**DARLING WALK EXTERNAL
DOMAIN**

ACCESSIBILITY REVIEW

Morris-Goding Accessibility Consulting

6th July 2009

PLAN 1:100

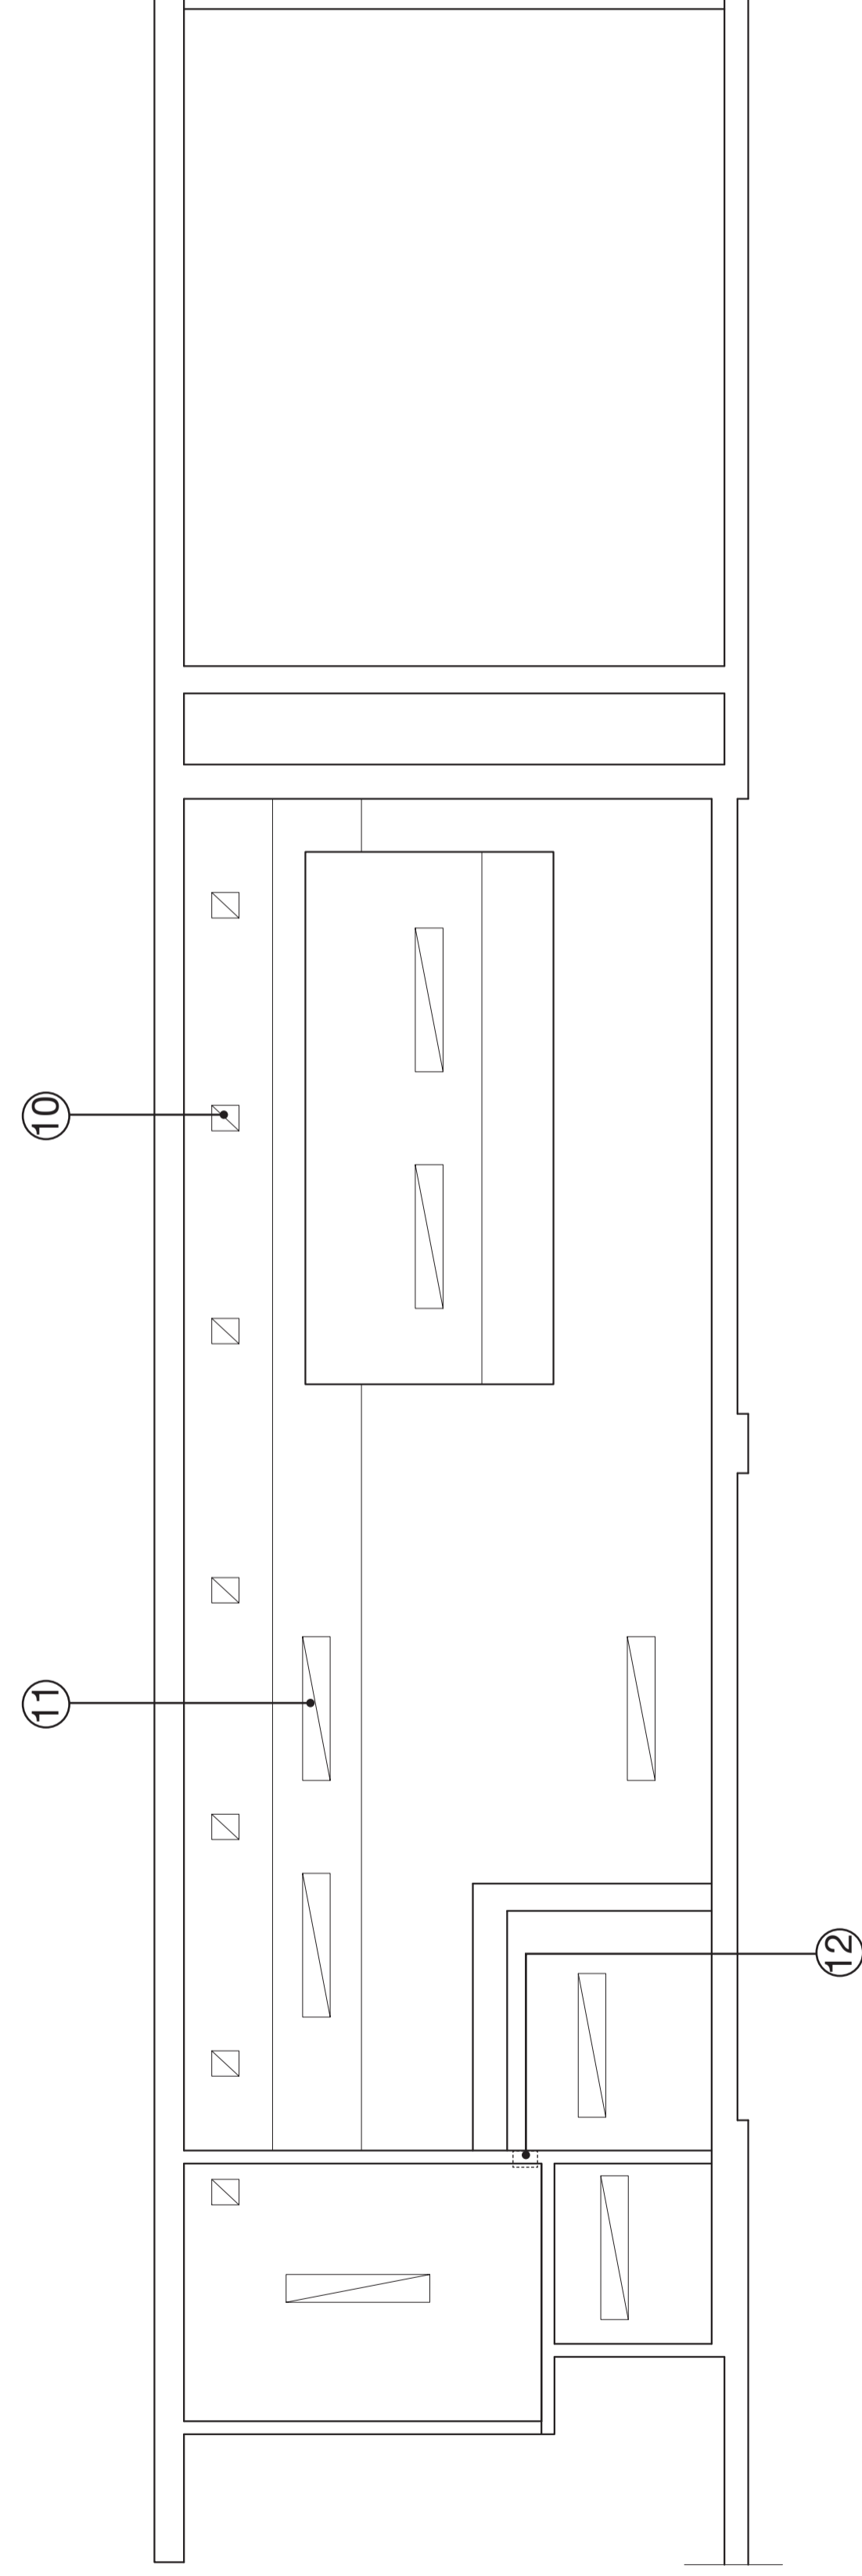
The Liverpool Street accessible toilet has internal dimensions that will satisfy AS1428.1 and BCA part D3. There will be suitable placement of pan and basin. The door swings outward to maximise the circulation area of pan and basin within the accessible WC.

There are appropriate paths of travel leading to the accessible toilet. The circulation areas in front of the accessible toilet door under AS1428.2.

- (i) Ensure there is a minimum distance of 1100mm between pan and basin

**Key: Seating**

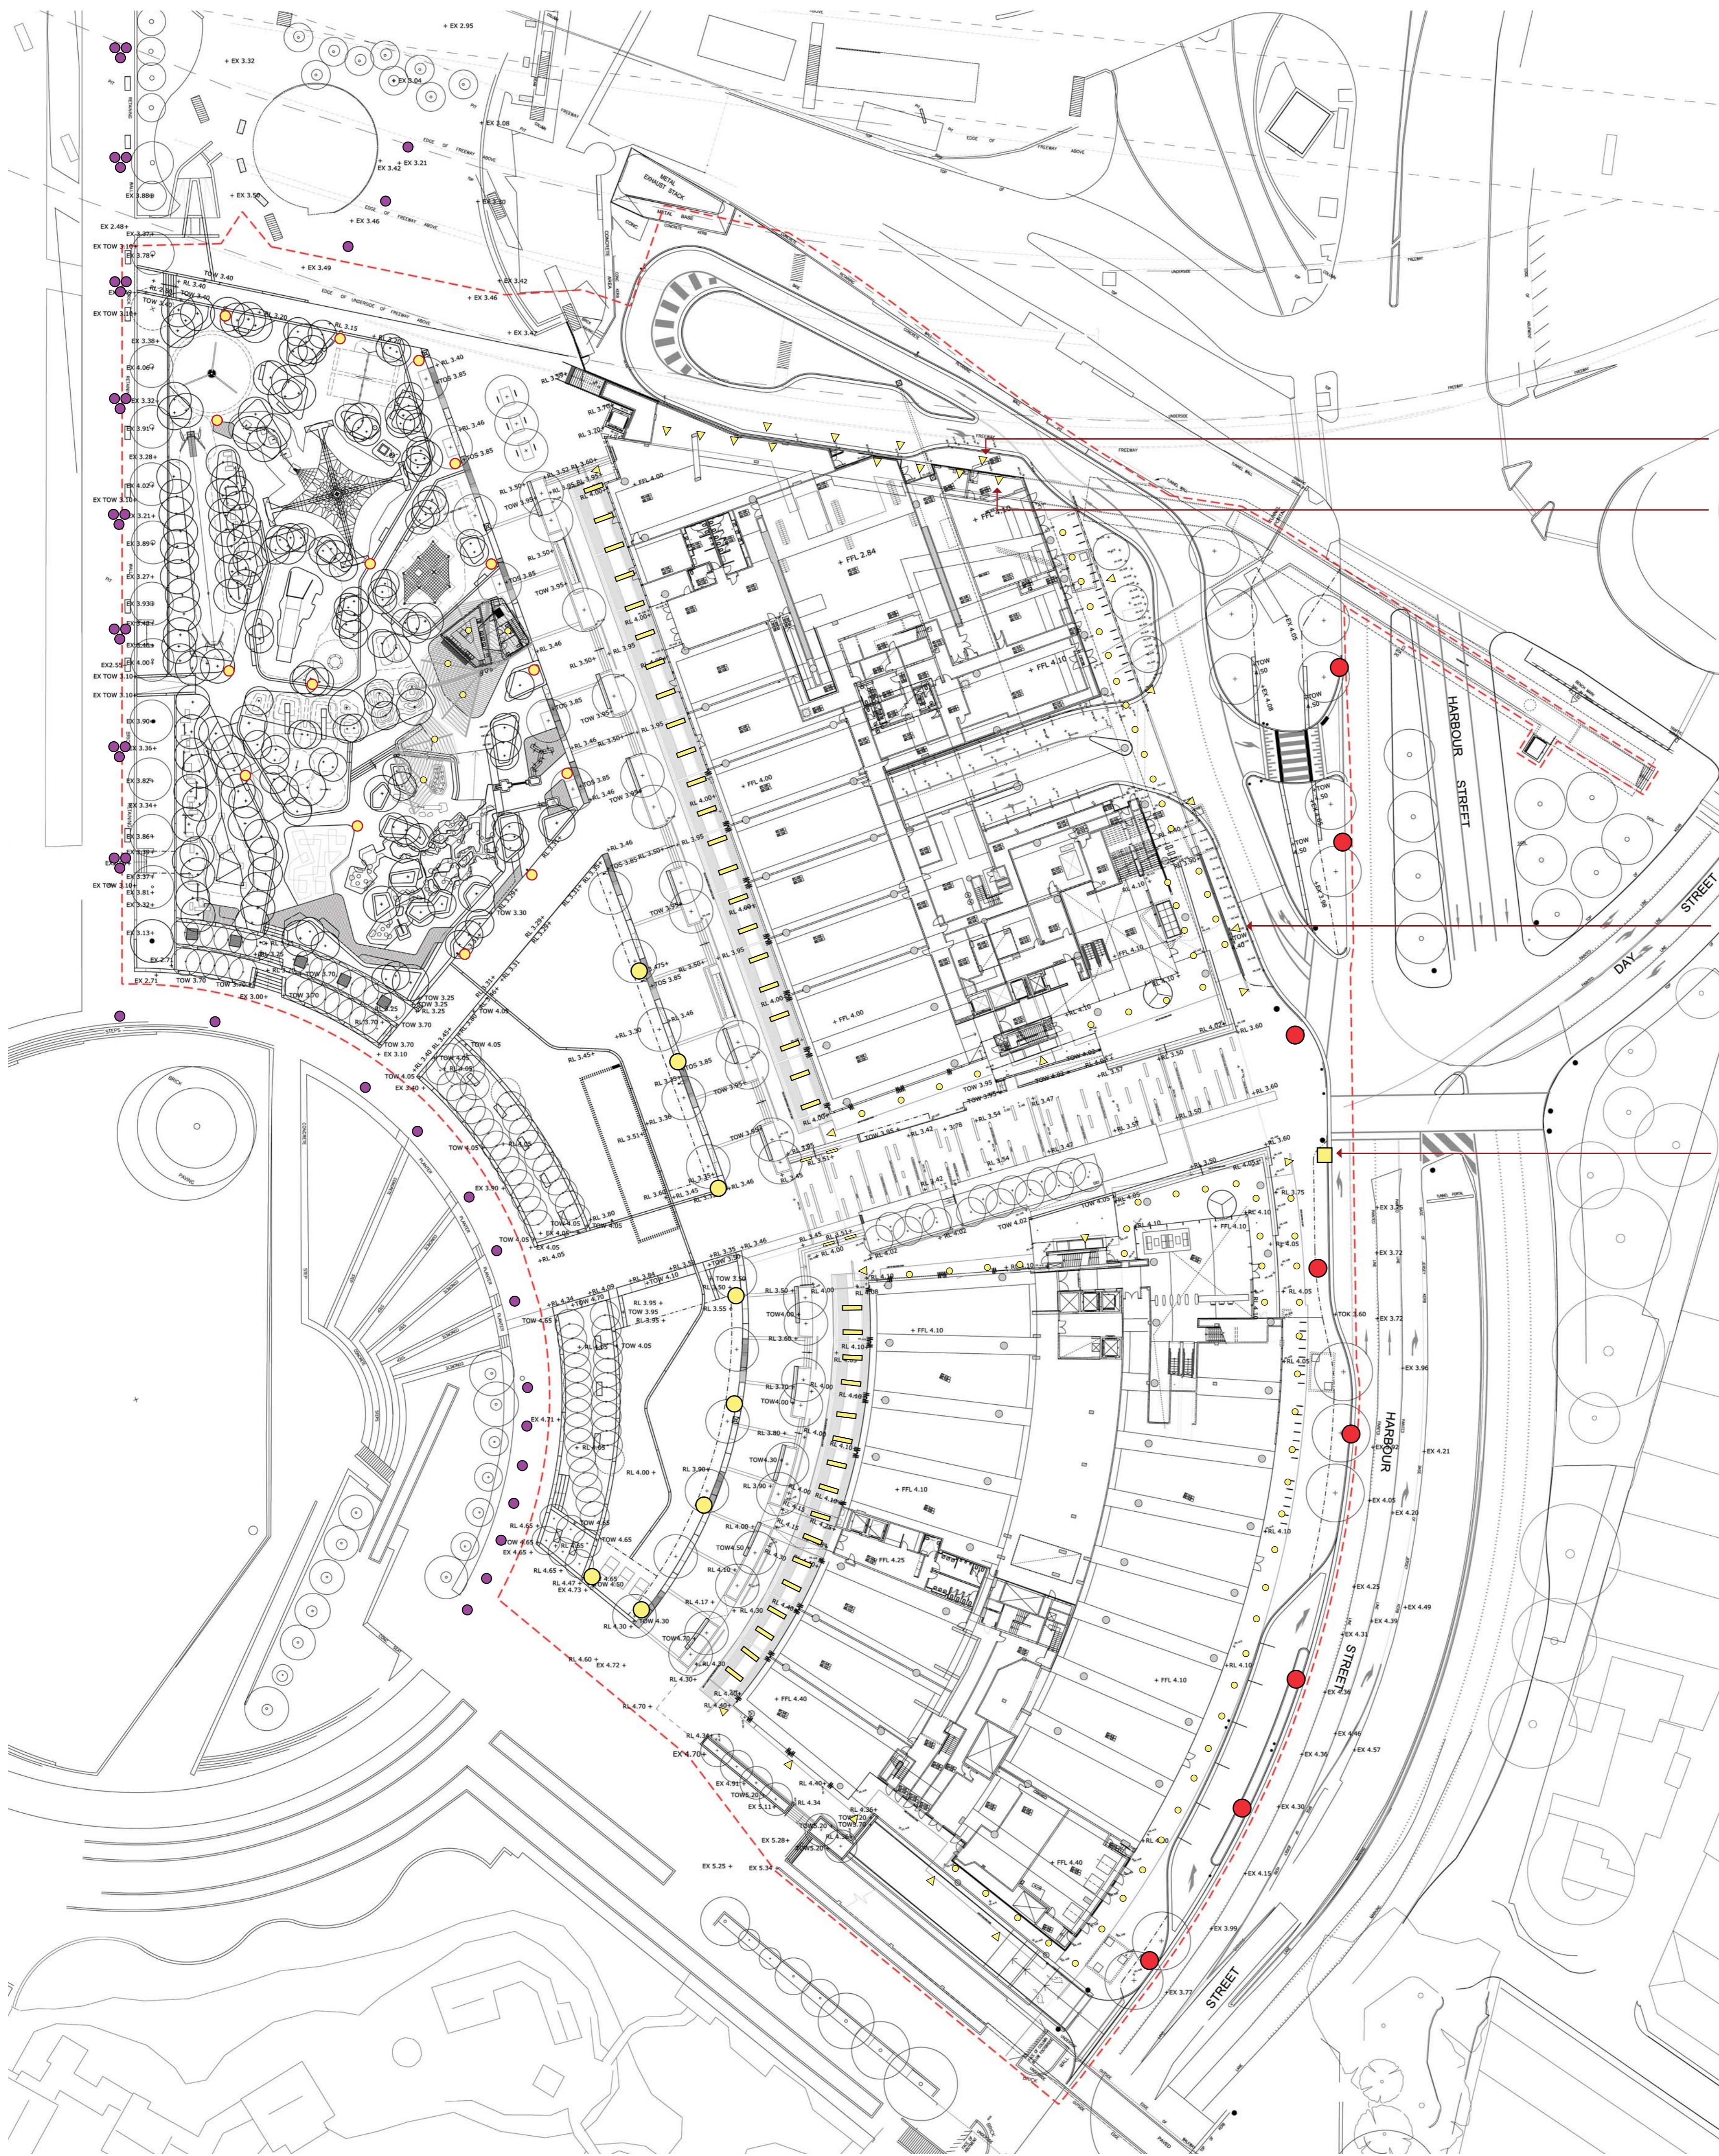
- (ii) Provide rest seating along all paths of travel at intervals of 60 metres. Rest seats to have back support and arm rests, where possible. Some rest seating should have shade.
- (iii) Objects such as rubbish bins, bollards, street lighting, and seats shall be recessed from the footpath and shall be of a colour, which provides a contrast with their background and have a luminance factor of not less than 30%.

**4.2 Amenities & Retail Kiosks Floor Plan**

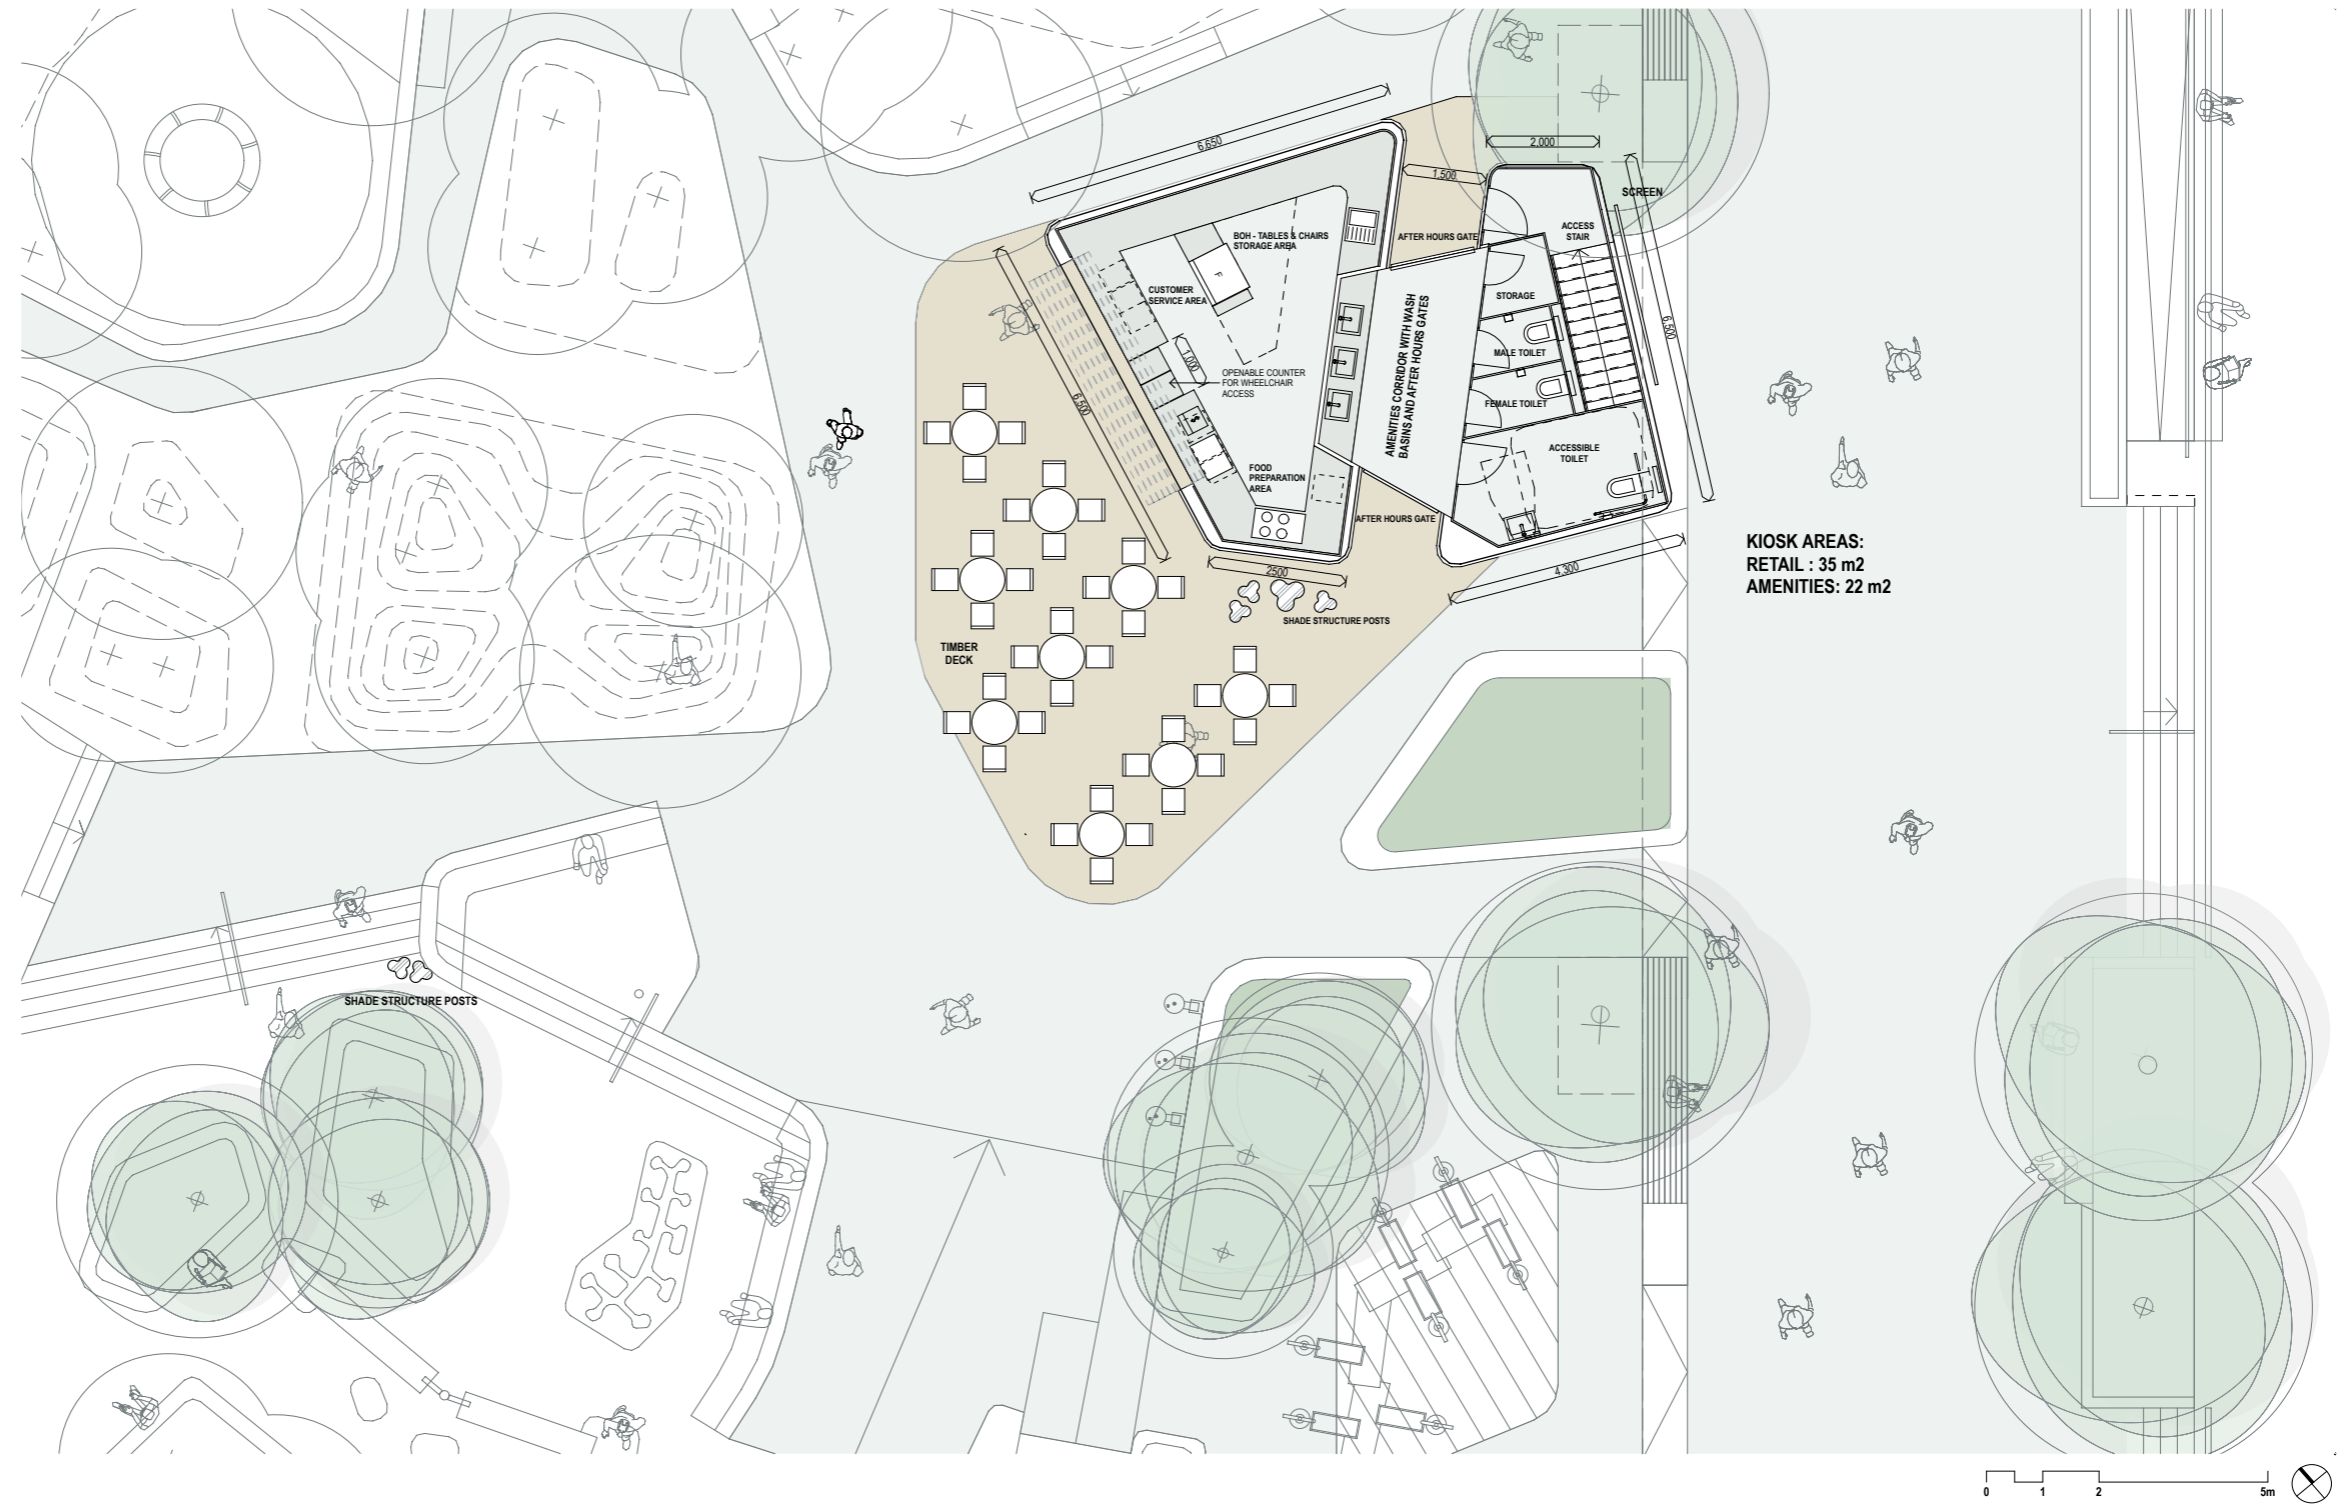
The kiosk accessible toilet has internal dimensions that will satisfy AS1428.2 and draft DDA Premises Standards. There is suitable placement of pan and basin. There are appropriate paths of travel leading to the accessible toilet.

The amenities corridor has suitable circulation area in front of the accessible toilet door under AS1428.2
